Ian Maguire
Assistant Director Planning
& Economic Growth

Our Ref: 20201222

Date: 23/12/20

RE: Deadline 6 Submission in respect of the Application by AQUIND Limited for an Order granting Development Consent for the AQUIND Interconnector Project.

**Plate 1 - Typical Laydown Area Dimensions**

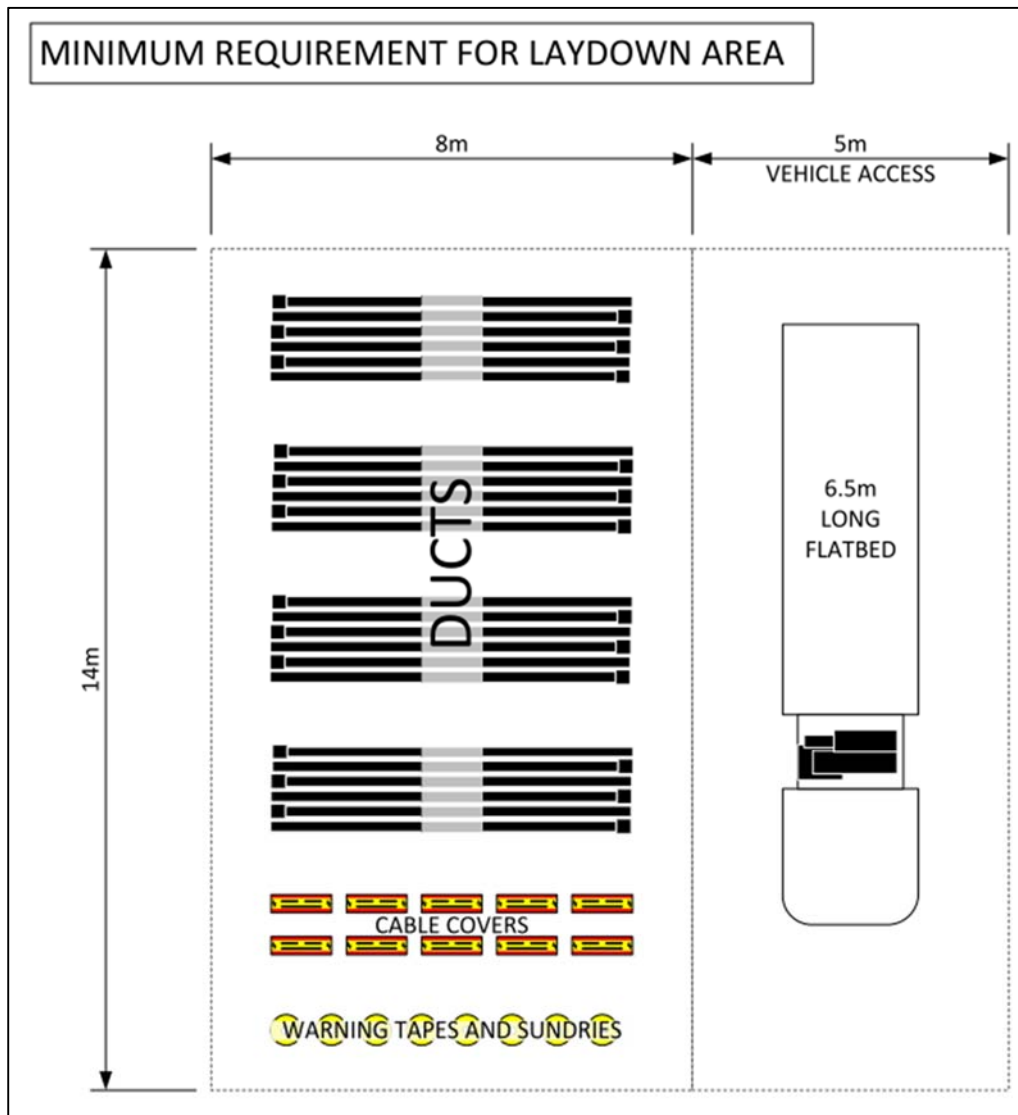
- 4.1.4 With regard to facilitating the construction, laydown areas for the Joint Bays and Joint Bay compounds are proposed to be created at Joint Bay locations (which are to be confirmed as part of the detailed design approvals). It is the LHA's established position however that these should not be created within the public highway at all (i.e. not just out with the carriageway). Although the

FCTMP makes no reference to likely locations it explains that access to these will be required *from* the highway. In the absence of detailed evidence of locations for the joint bays it is therefore not possible to establish whether or not such access can be achieved safely or the laydown areas / joint bay compound accommodated.

**Plate 3 - Typical arrangement of HVDC and FOC cables in roads, verges and footpaths (all measurements in mm)**

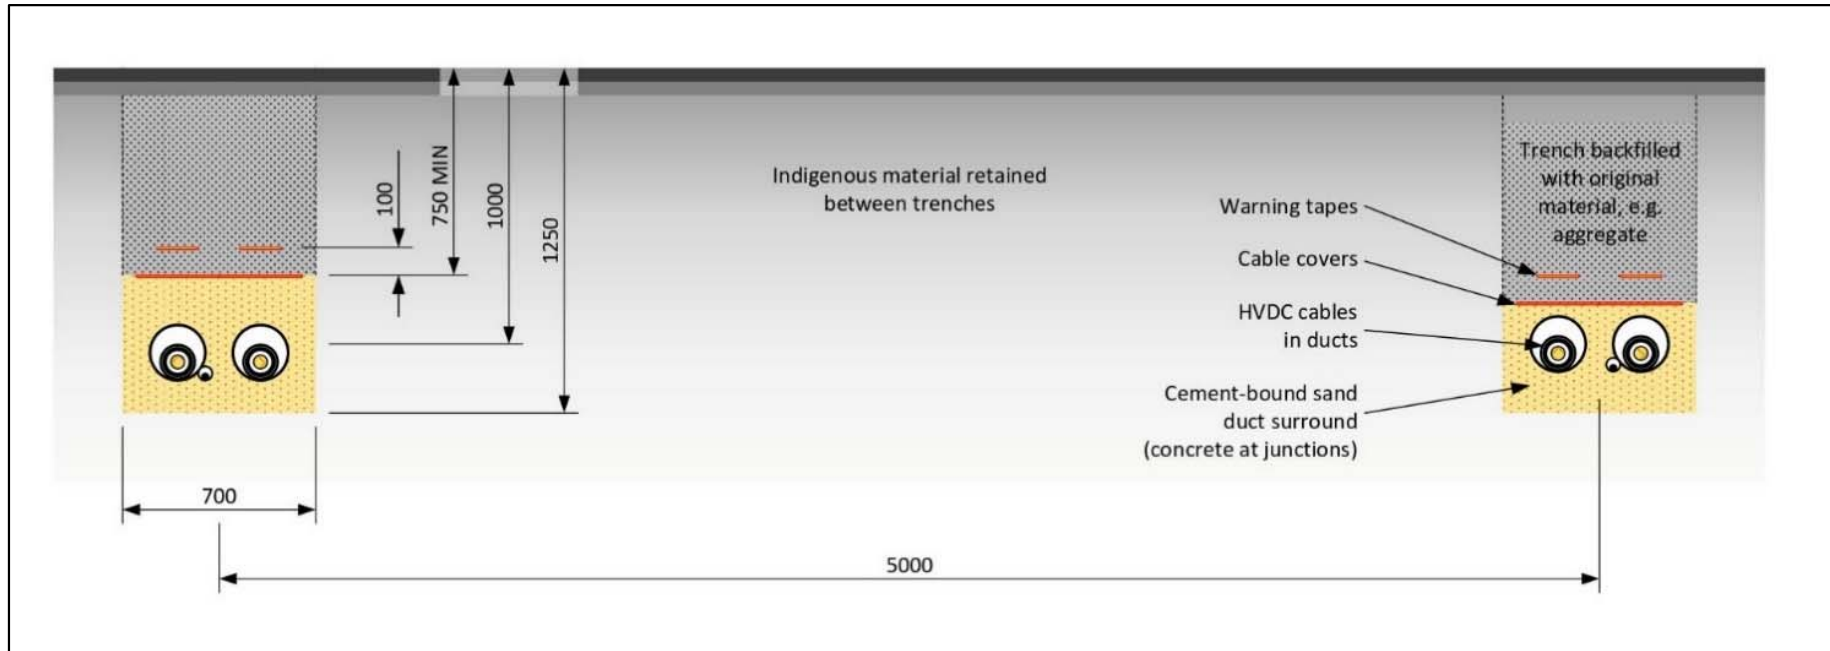
- 4.1.8 The FCTMP explains both horizontal drilling (HDD) and open cut trench methods to install ducts through which the cables will be drawn in section 2.9. The open cut trench method is intended to be used in the cable routes that fall within the highway and envisages a trench width of 700mm and depth of 1250mm. The Applicant's intention is to open and reinstate one trench before commencing another in any section with an installation rate of 12m -30m per shift (10hrs / day 6 days a week). The FCTMP is not specific however about the reinstatement requirement for the trenching although it is the LHA's position that where this is undertaken in carriageway the reinstatement provides for the resurfacing of the lane width.

4.1.22 The FCTMP does not in fact address the final reinstatement of trenching at all. PCC as the LHA suggests that where trenching is located in carriageway that a full lane width resurfacing is required to be undertaken as a part of the final reinstatement to preserve the structural integrity of the carriageway. This needs to be reflected in the FCTMP.
